Interested Party Reference Number [REDACTED]

Representation by Mike Lambert, on behalf of Aldham Parish Council

APP-012 EN020027-000244-2.2 Sheets 6-8

Detailed Assessment of Route through Aldham Parish

Figure 4.4 Aldham

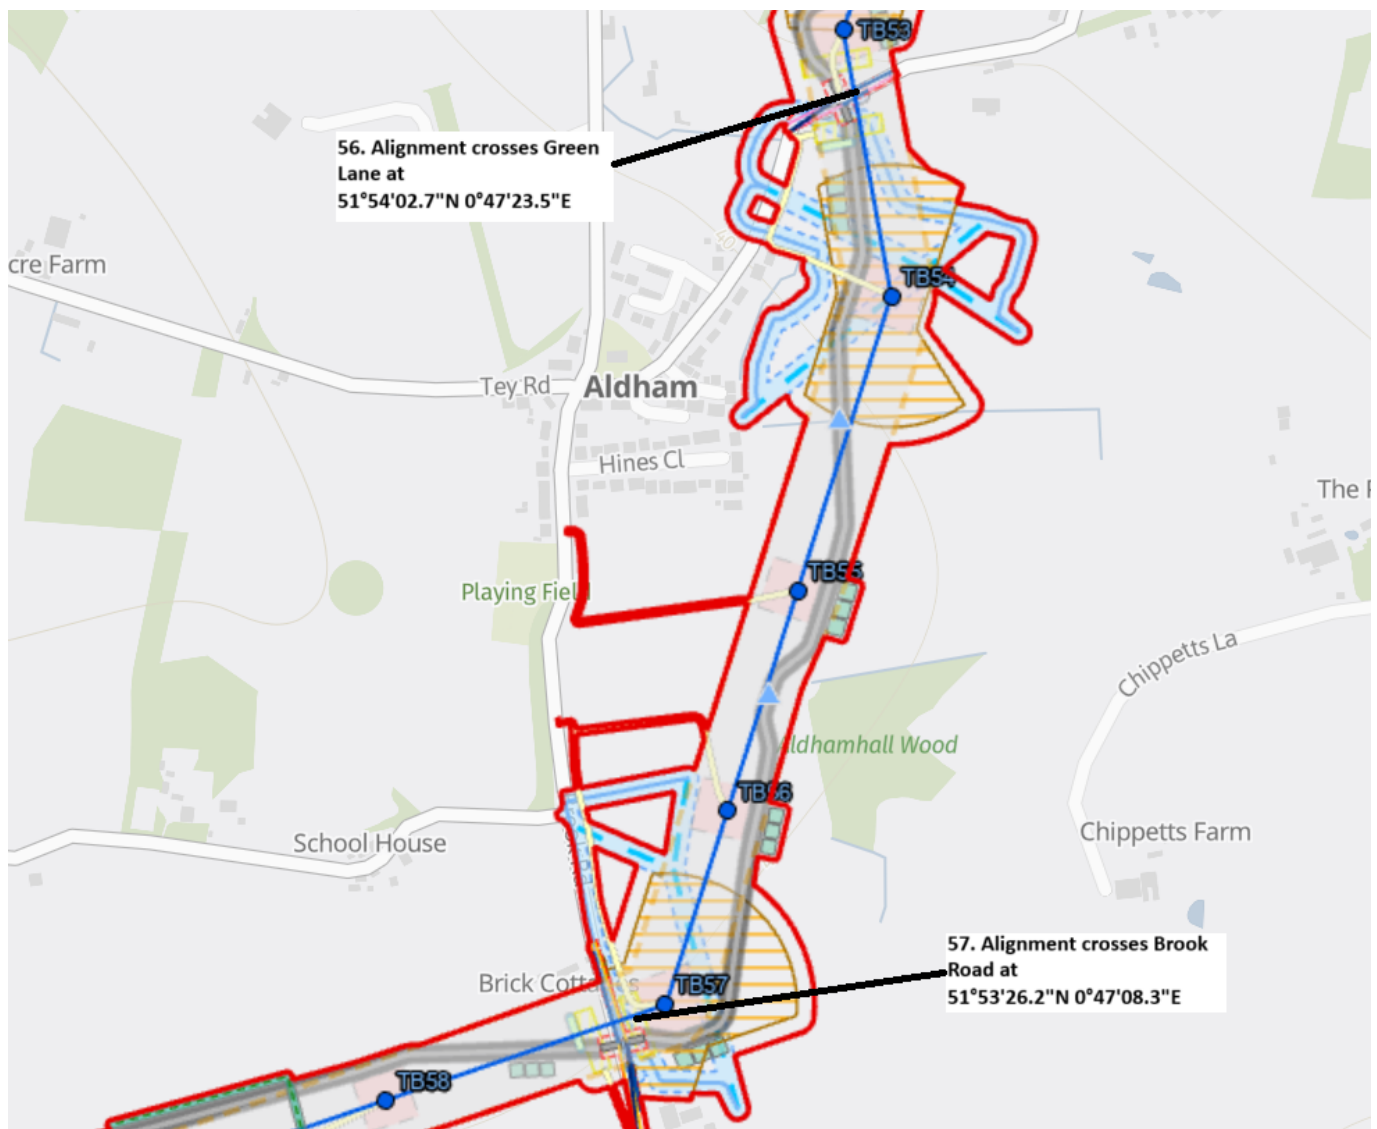
TB054 will be 140m from the back of the nearest houses in Green Lane and will adversely affect the outlook from 20 properties on the south east side of the Lane and Church Grove, creating an intrusive feature in uninterrupted views across open countryside. From Green Lane to a mid-point between TB054 and TB055 the haul road is sited to the west of the pylons and OH lines meaning it will be less than 90m from the nearest property on Green Lane. This is likely to cause a loss of amenity through noise and disturbance for an extended period during construction.

The OH line continues to pass close to residential properties in Hines Close and TB055 is also only 140m from the rear of the nearest properties on the southside of Hines Close, adversely affecting residential amenity during and after construction.

Pylons TB054 to TB057 form a line angling away from Brook Road when approached from the south, creating a solid wall of lines and latticework that will harm the setting of St Margaret's and views of the spire. Furthermore, there will be serious detriment to the setting of the Grade II* listed buildings at Aldham Hall, from the proximity and impact of TB057 and in the short term from the proposed haul road crossing Brook Road between Aldham Hall and Brick Cottages. In particular, TB057 is only 100m south east of Brick Cottages and both properties will be affected by noise and general
